An
Bord
Pleanála

Oral Hearing Agenda

**ABP-317560-
23**

Case	Proposed Hydrogen Plant and Wind Farm
Start Date	20.03.2024
Start Time	10:00 a.m. (9:30 a.m. from Day 2 onward)
Location	Microsoft Teams

Figure 1.3 Hydrogen Plant Site House Locations

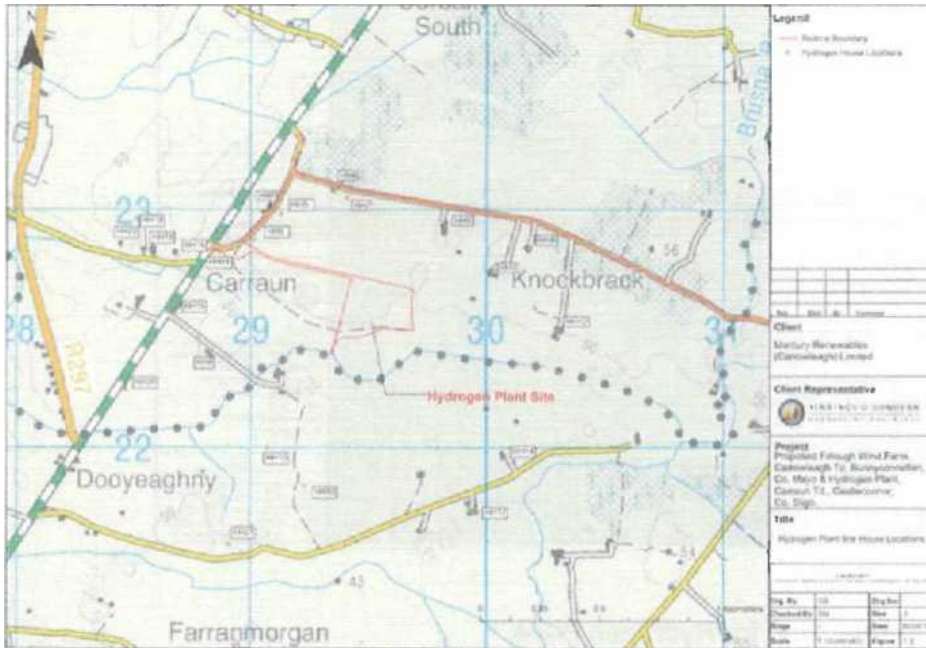
4 (e) Confirm approach to including housing on the noise map for the hydrogen plan (11.5 – 11.9) and Fig. 1.3.
